| <b>Consultation Response from KC, Highways Development Management</b>  |                                     |                                 |
| <b>2021/91975 Croft House Surgery, 1145, Manchester Road, Slaithwaite, Huddersfield, HD7 5JY</b>   |                                     |                                 |
| <b>Redevelopment of Croft House Surgery with demolition of existing 2 storey flat roof car port / office building, alterations to existing building to form 4 residential units and erection of 2 dwellings (within a Conservation Area)</b>   |                                     |                                 |
| <b>Date Responded: 16/11/21</b>  | <b>Responding Officer: J Turner</b> | <b>Responding Ref: K1-42/25</b> |

| Drawing Proposed Ground Floor Site Plan | Scale @ A1 1:100 |

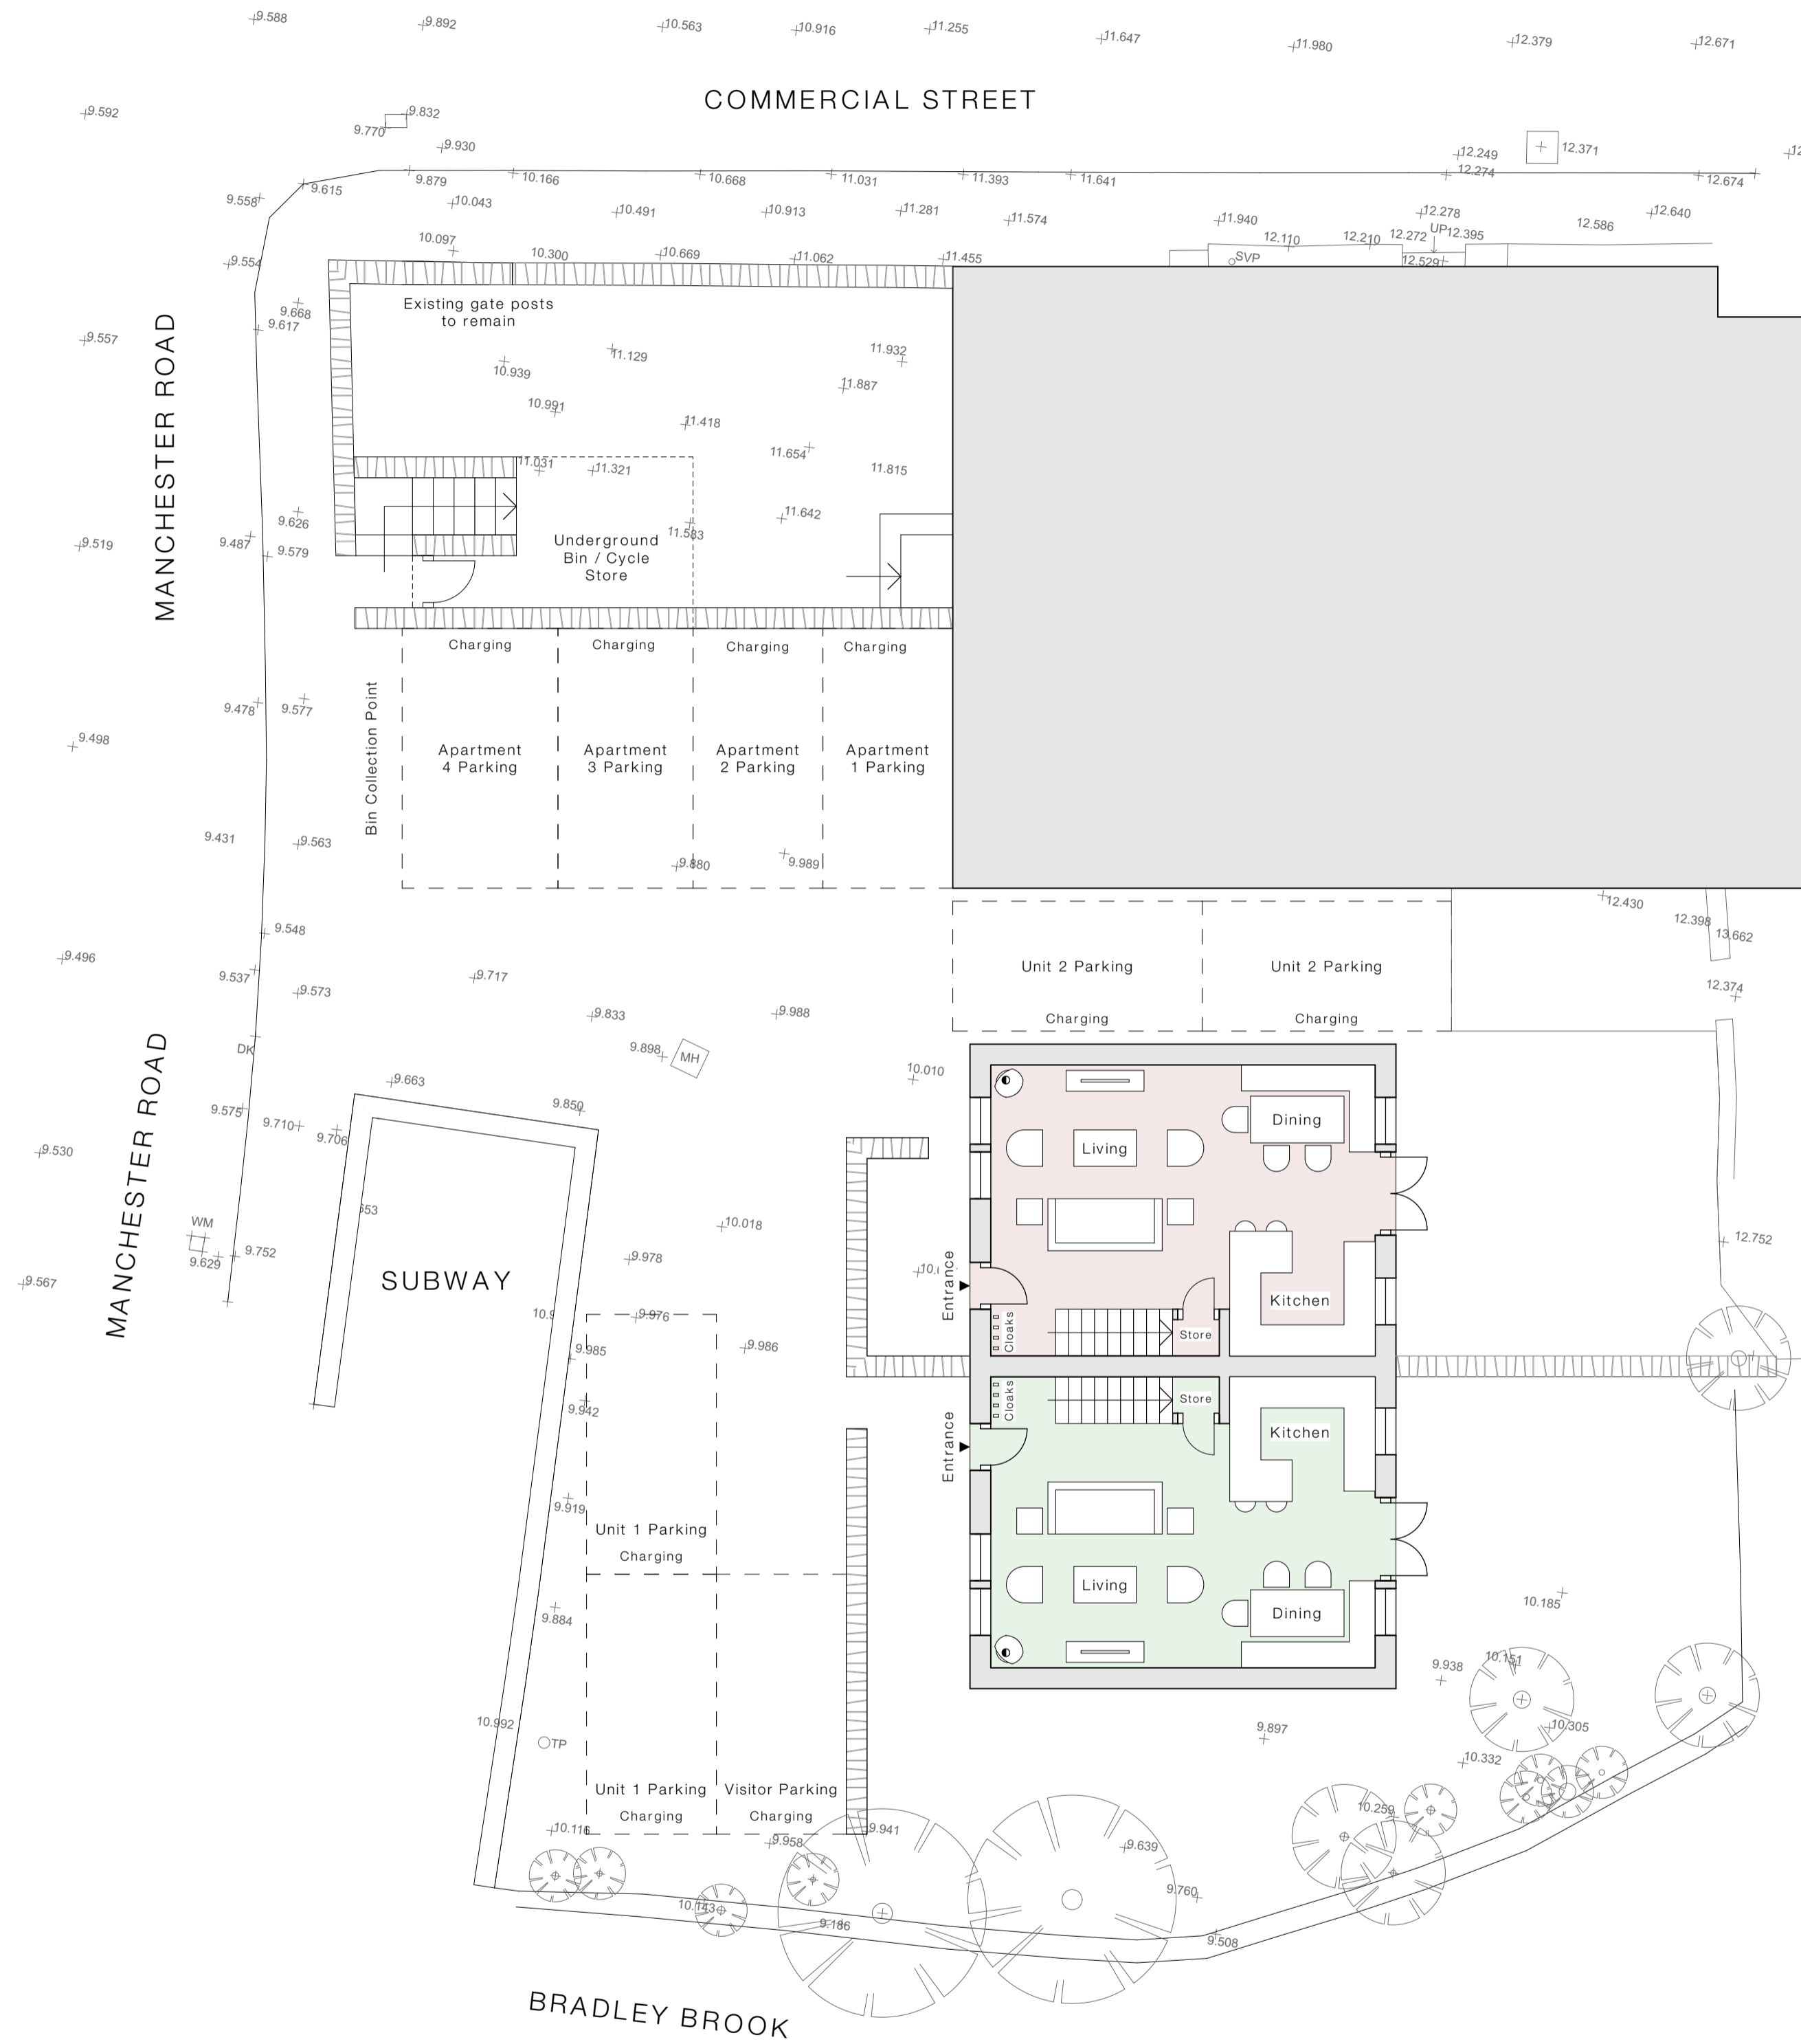
| <p>This application seeks approval for the redevelopment of Croft House Surgery with demolition of existing 2 storey flat roof car port / office building, alterations to existing building to form 4 residential units and erection of 2 dwellings (within a Conservation Area) at Manchester Road, Slaithwaite.</p> <p>Further to previous comments, the off-street parking has been slightly amended and has now been demonstrated to allow for vehicles to access and egress in a forward gear.</p> <p>However, concerns were raised regarding bin and cycle storage as per the below:</p> <p>“Bin and cycle storage appears to be underground. Even if these were private bins for each apartment, it isn’t acceptable to expect resident to pull their full bins up a flight of stairs to be presented for collection. Given the apartments may share one large communal bin, this is even less of a practical arrangement. This should be rectified, and the proposed bin storage and collection spaces dimensioned on a plan. Additional detail on the proposed cycle store (dimensions, cycle stand design and installation etc.) should also be submitted.”</p> <p>No further details have been supplied, and the present arrangement would likely see resident leave their bins in the collection point rather than have to carry them up and down steps that include a 90° turn each week. There has still been no confirmation that the storage space is fit for purpose in terms of available floor space or adequate cycle storage.</p> <p>Given the above, Highways DM cannot support the scheme as the intentions for cycle and bin storage are unacceptable.</p> |                                     |                                 |
